DECISION DELEGATED TO HEAD OF PLANNING

Application No: H14-0224-24 **Applicant:** Cecil Francis Ltd

Proposal: Details of surface water disposal, external materials, external doors/door frames, window frames and gas/electricity boxes (Conditions 9, 14, 15, 16 and 19 of H14-0706-22)

Location: Cecil Francis Ltd Bear Lane Pinchbeck

North West Elevation
Scale 1:50

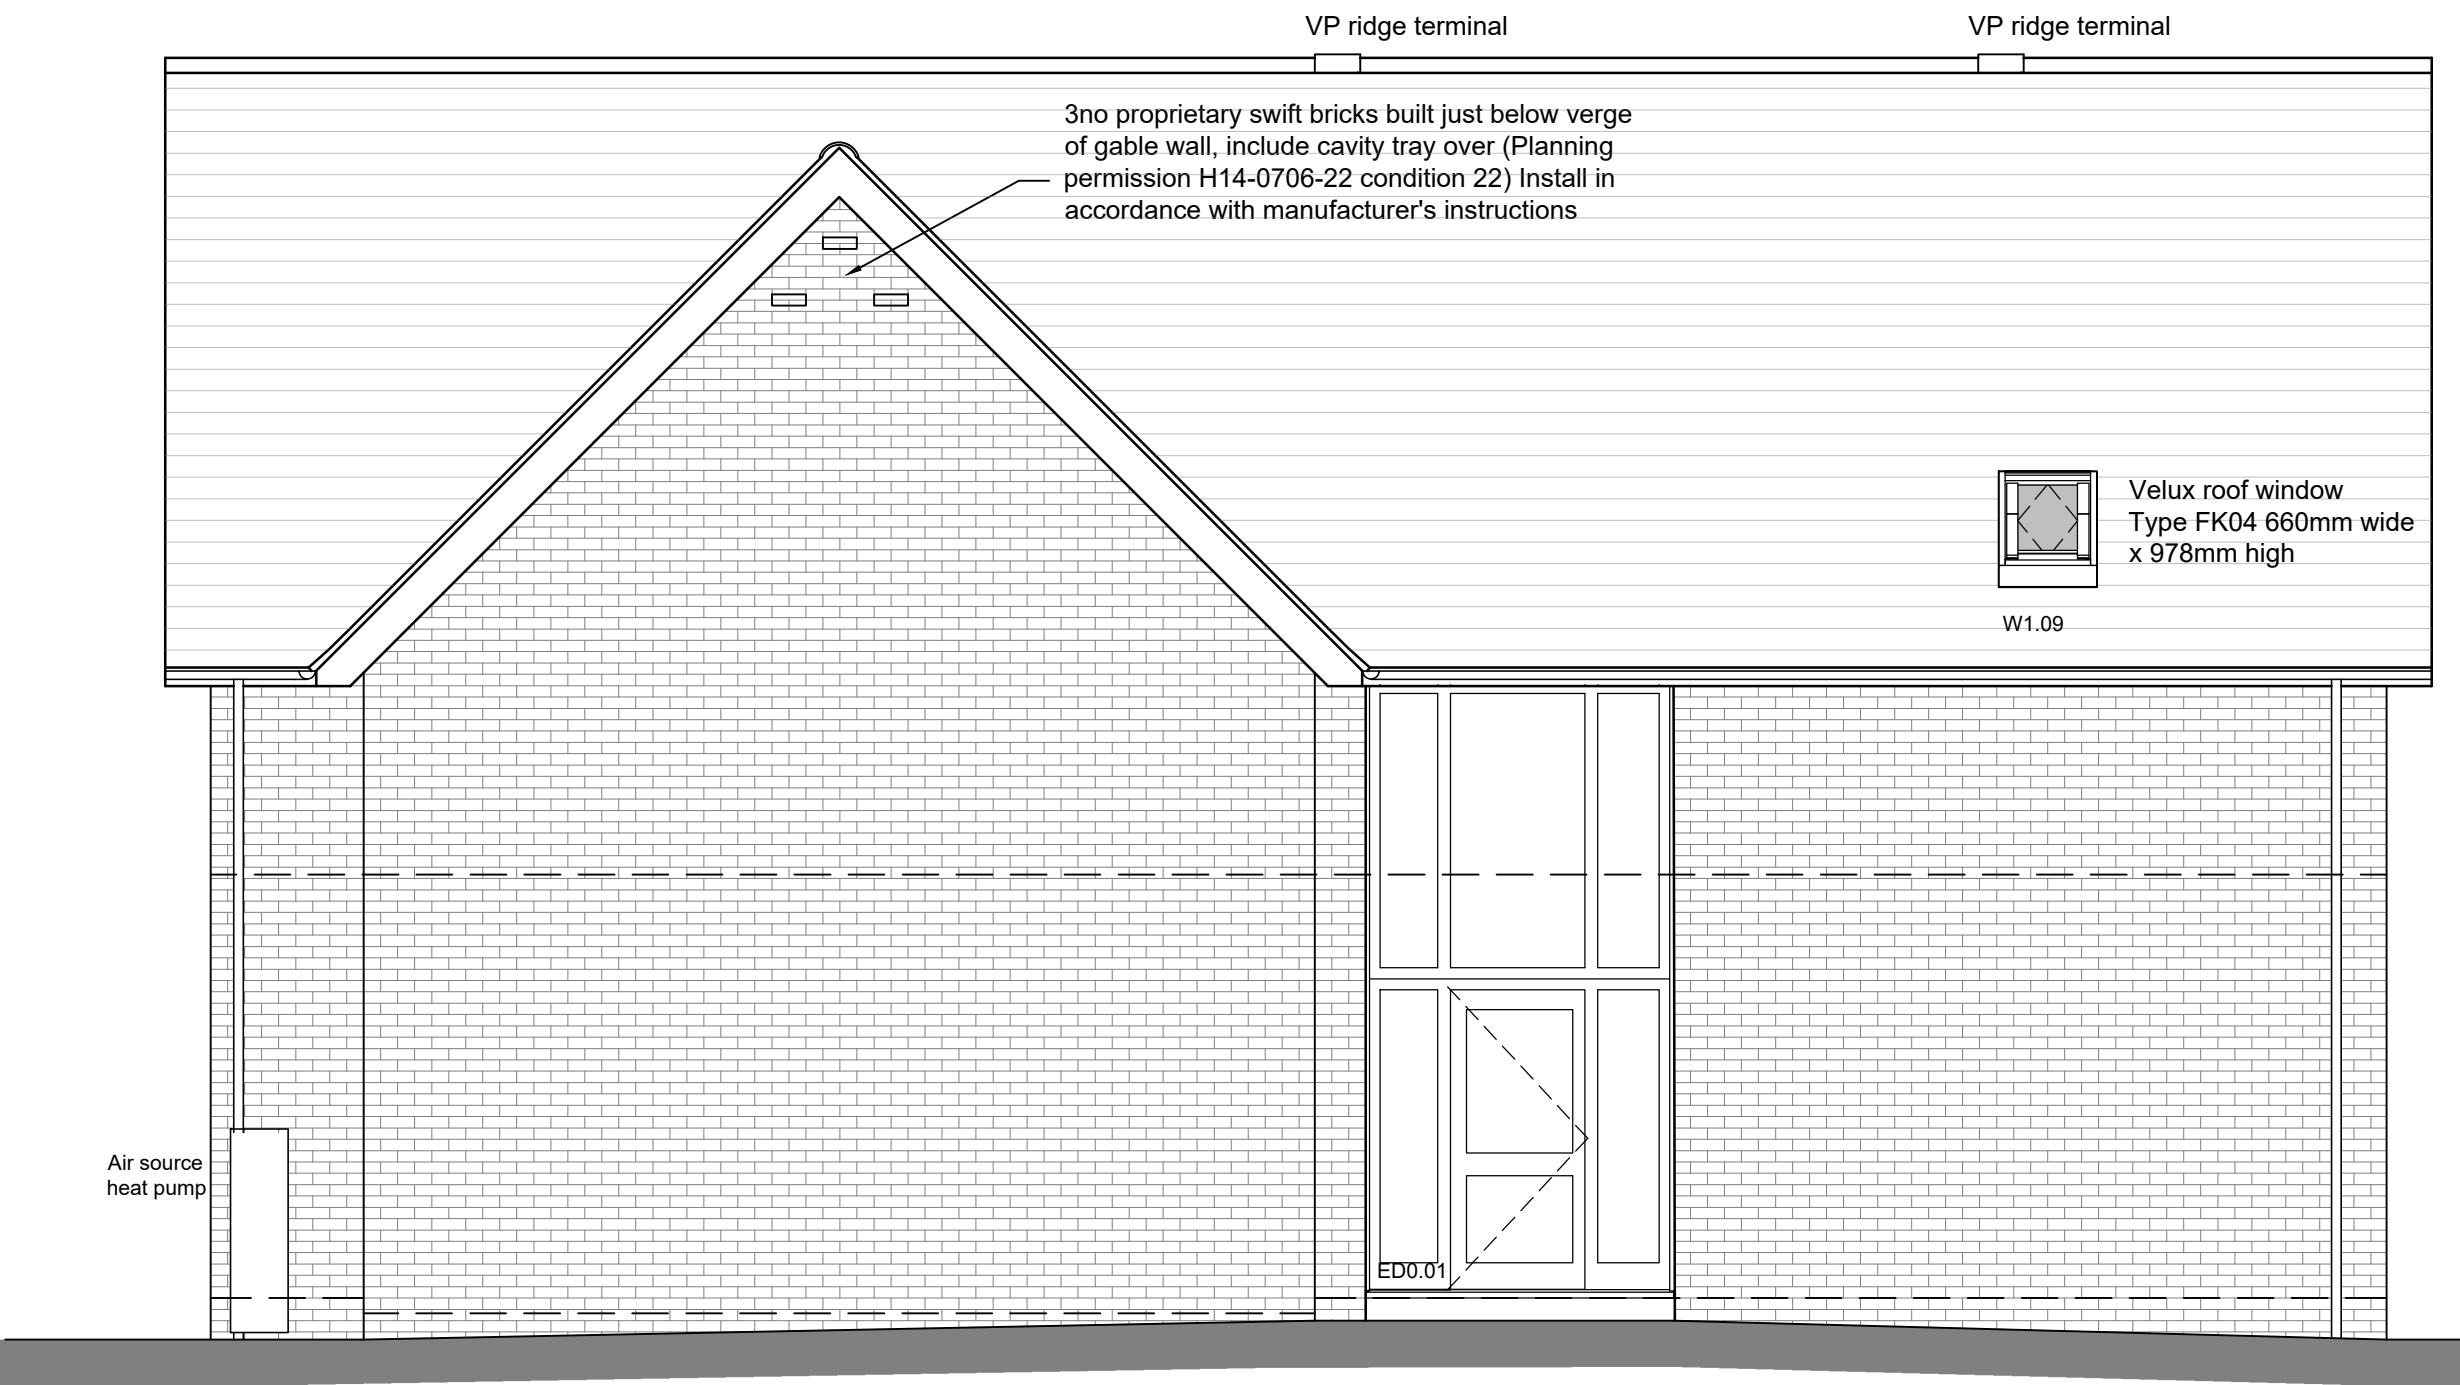
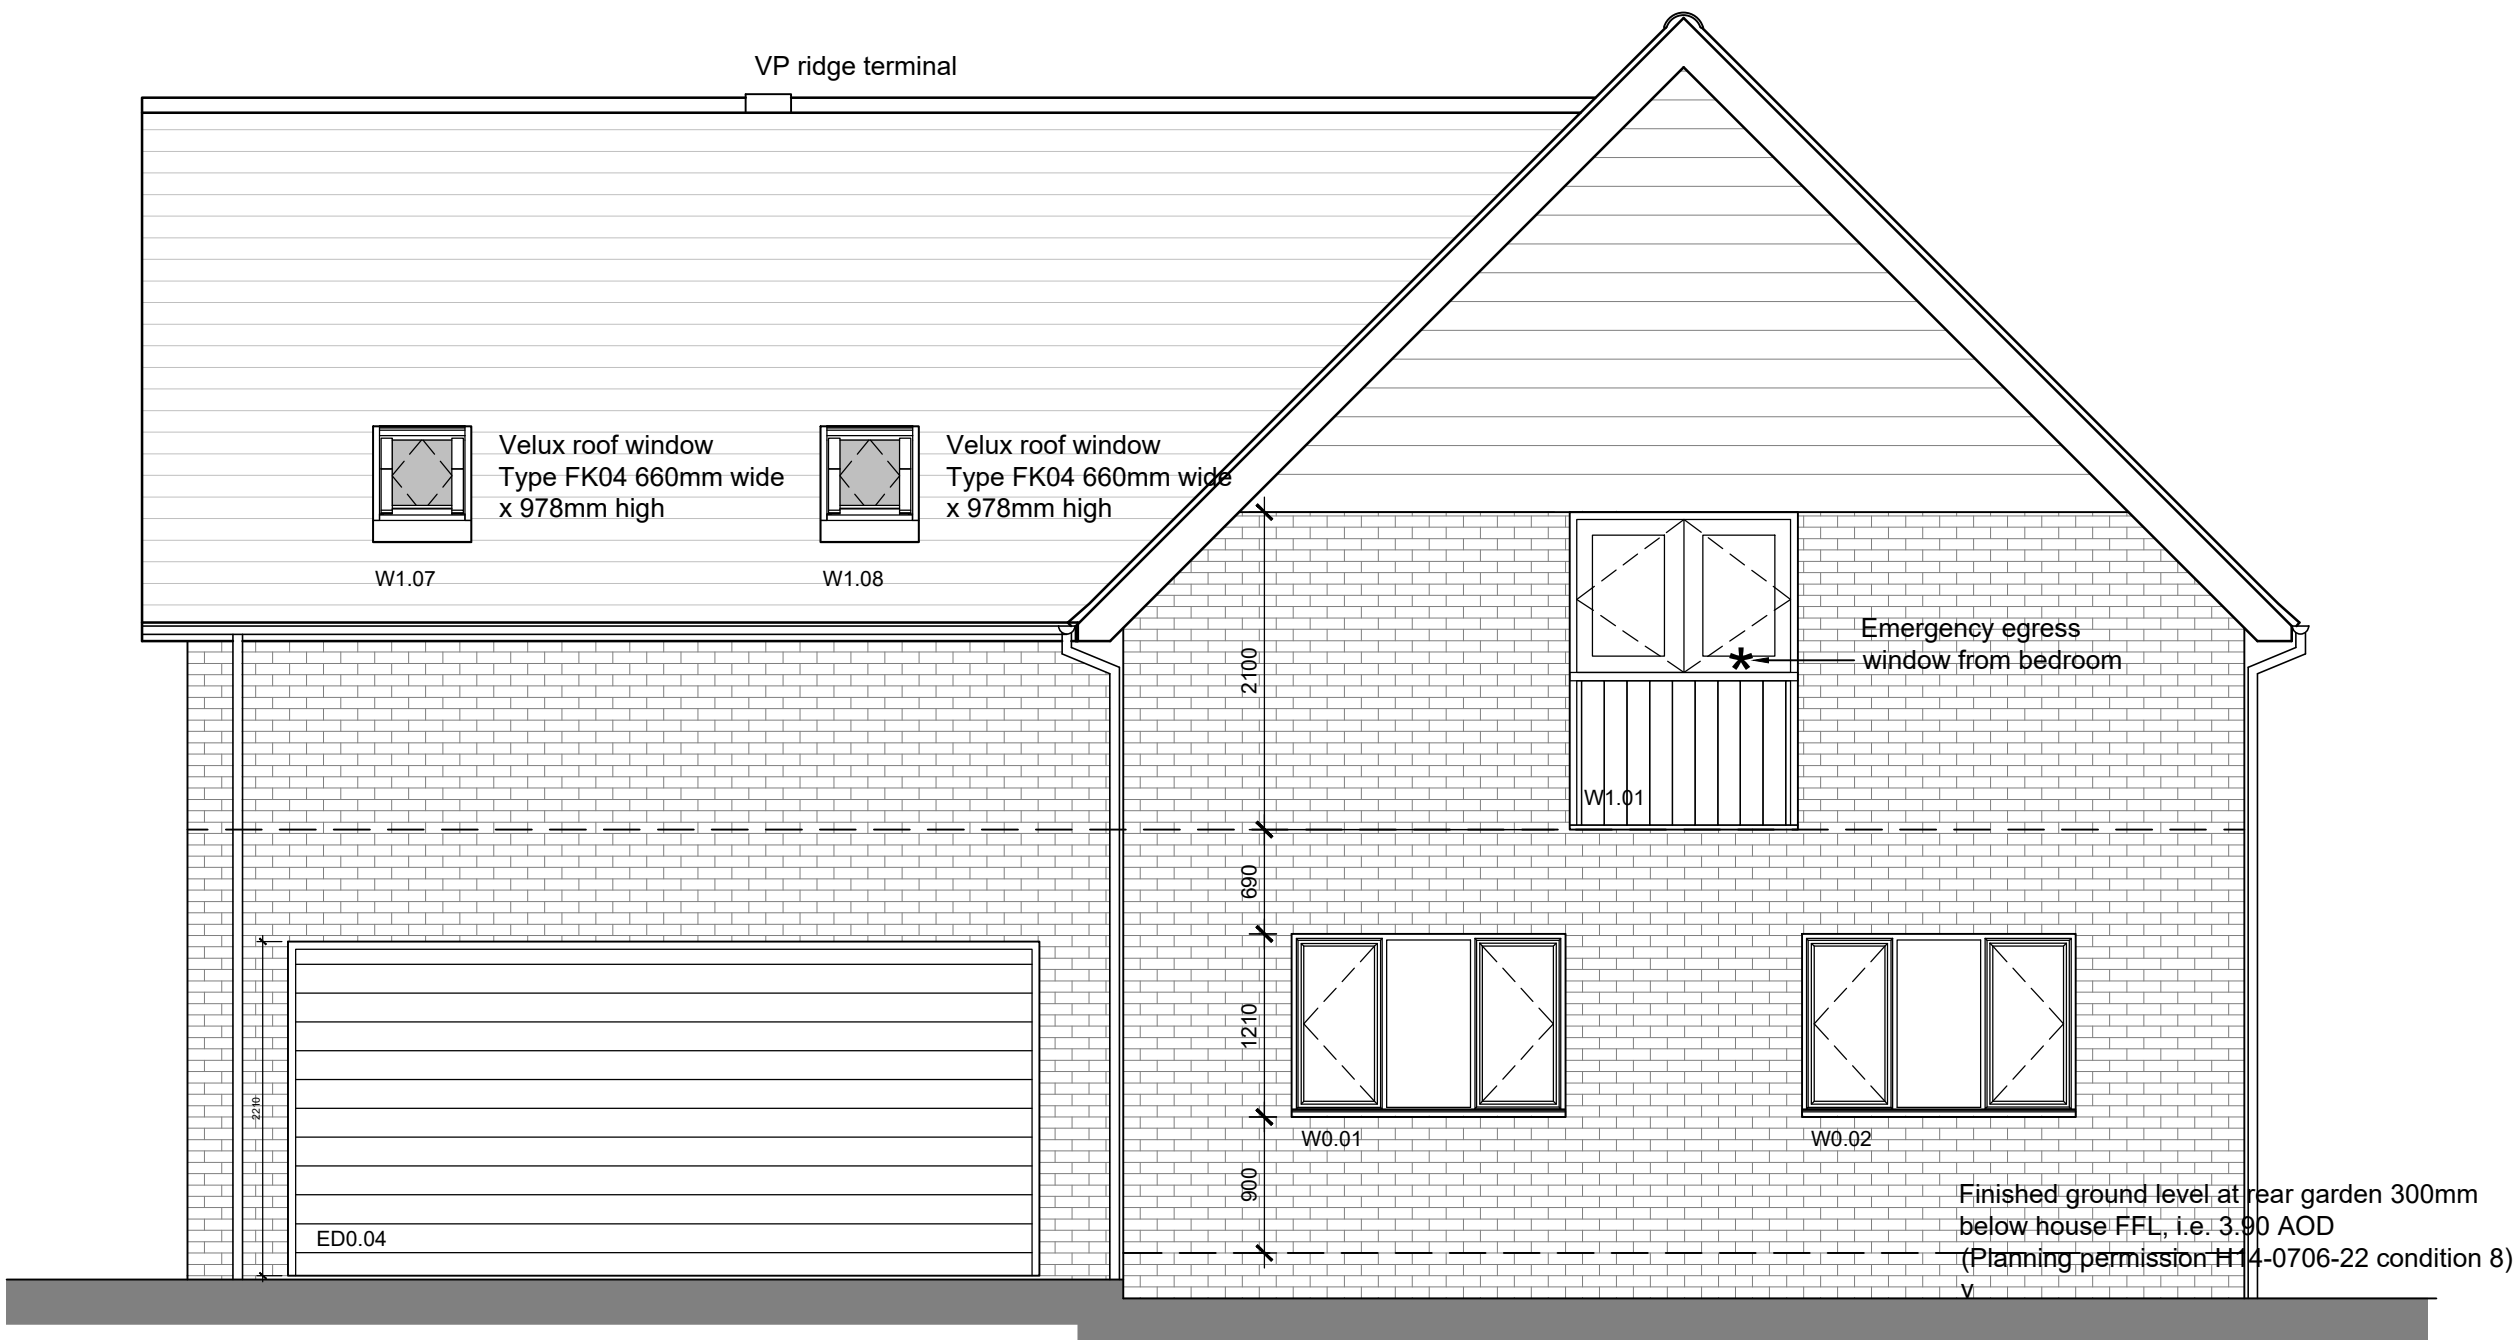
Plots 1 and 3 show on the north east elevation two velux roof windows, two casement windows at ground floor level, and an upper emergency access window at first floor.

For Plots 1 and 3 the electrical cabinet is shown on the north west elevation. It is a standard cabinet in white. The air source heat pump is shown on the south west elevation in the centre of the site away from neighbours on the rear elevation. It only comes in a standard grey colour and is an Ecodan R32 Air Source Heat pump.

It is considered that the details are satisfactory and condition 16 can be discharged.
